Your ref: SSD-50505215

Our ref: DOC24/699892

Subject: Bullawah Wind Farm (SSD-50505215)

ATTACHMENT A – BCS Assessment Summary for Bullawah Wind Farm Environmental Impact Statement (SSD-50505215)

- Legend**
- Project Area
 - Hydraulic Model Domain
 - Hardstand
 - Development Area
 - Major Track
 - Minor Road

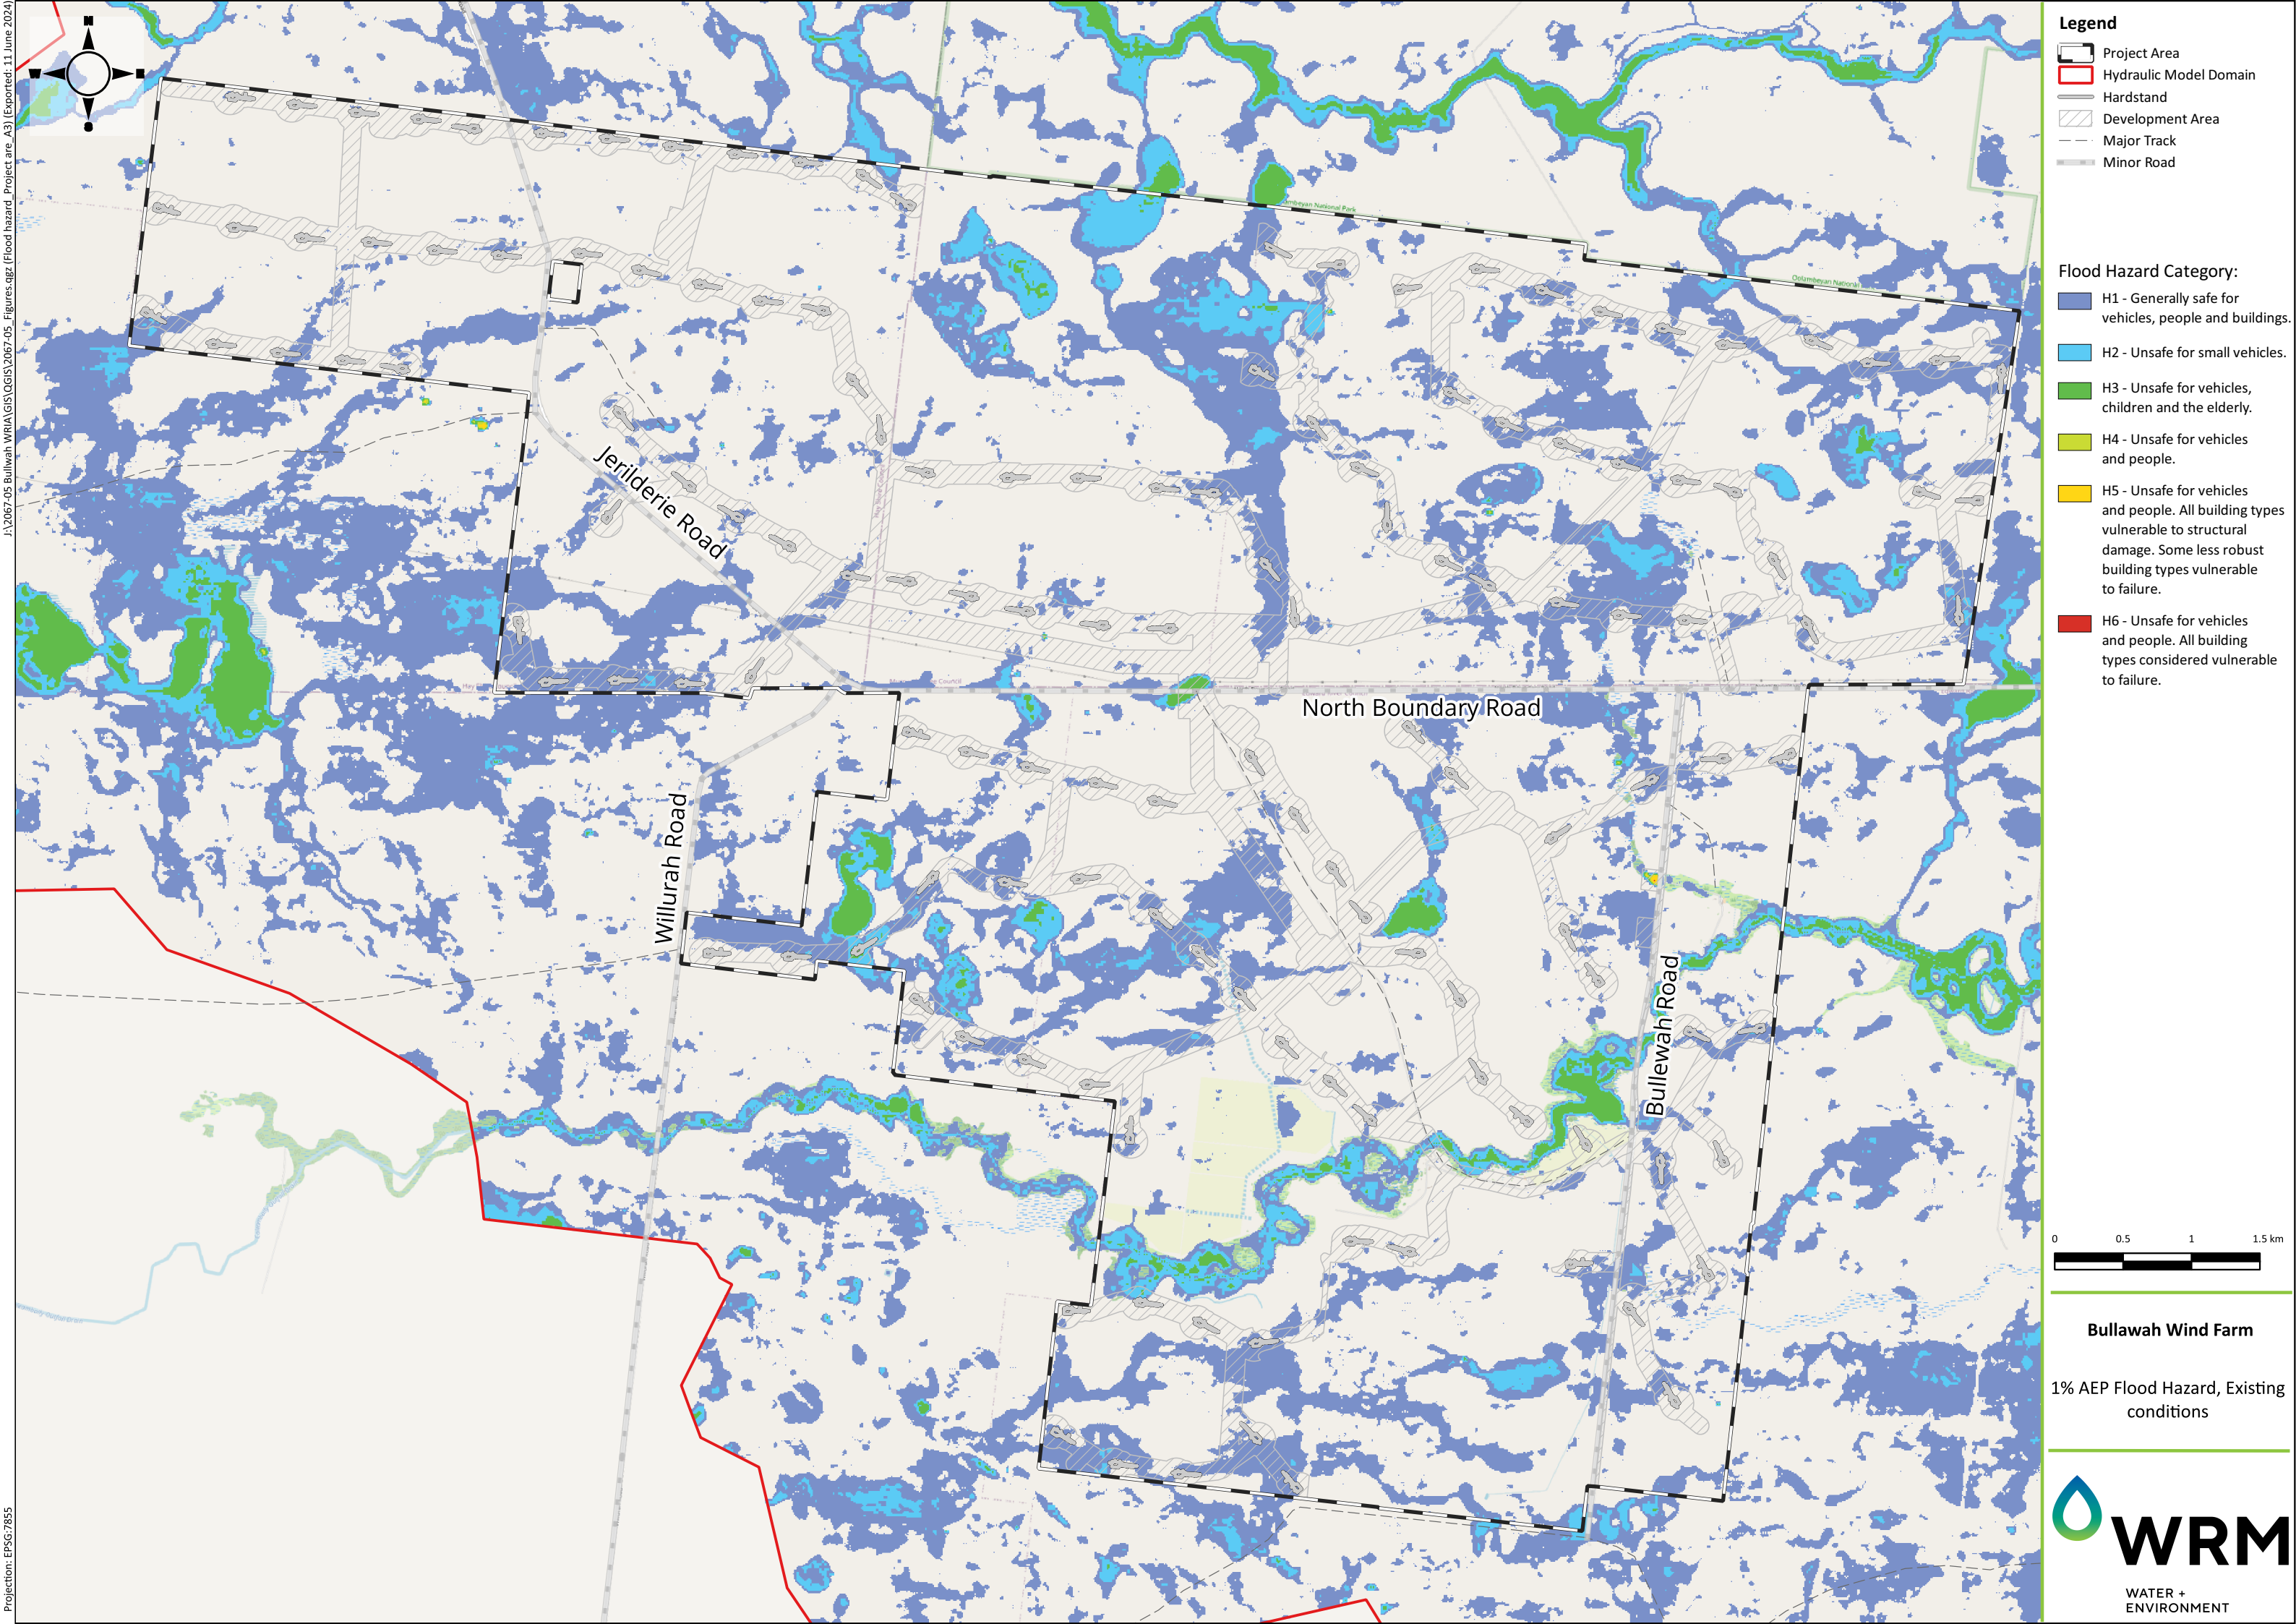
3. The flood modelling and mapping needs to include more detail of the project infrastructure to adequately inform the flood behaviour and flood risk assessment.

The Bullawah Wind Farm Project Water Resources Impact Assessment provides low-resolution mapping in its overview of the project. The mapping provides limited detail of the proposed project infrastructure, including ancillary works, in the landscape. As such, BCS is not able to determine the impact of the entire project on flood behaviour and the flood risks to the project infrastructure.

The proponent needs to complete clear and detailed mapping of sensitive and hazardous infrastructure, such as the temporary workers' accommodation, battery storage and multiple substations to allow appropriate flood risk assessment to be completed. BCS recommends that future hydraulic modelling is based on the detailed design for the project infrastructure, which will include all aspects of development, to ensure the impact of the project on flood behaviour and the flood risks to critical project infrastructure are adequately assessed.

- 3.1. Ensure future hydraulic models include the detailed design for the proposed project infrastructure to ensure the impact of the project on flood behaviour and the flood risks to critical infrastructure are adequately assessed.
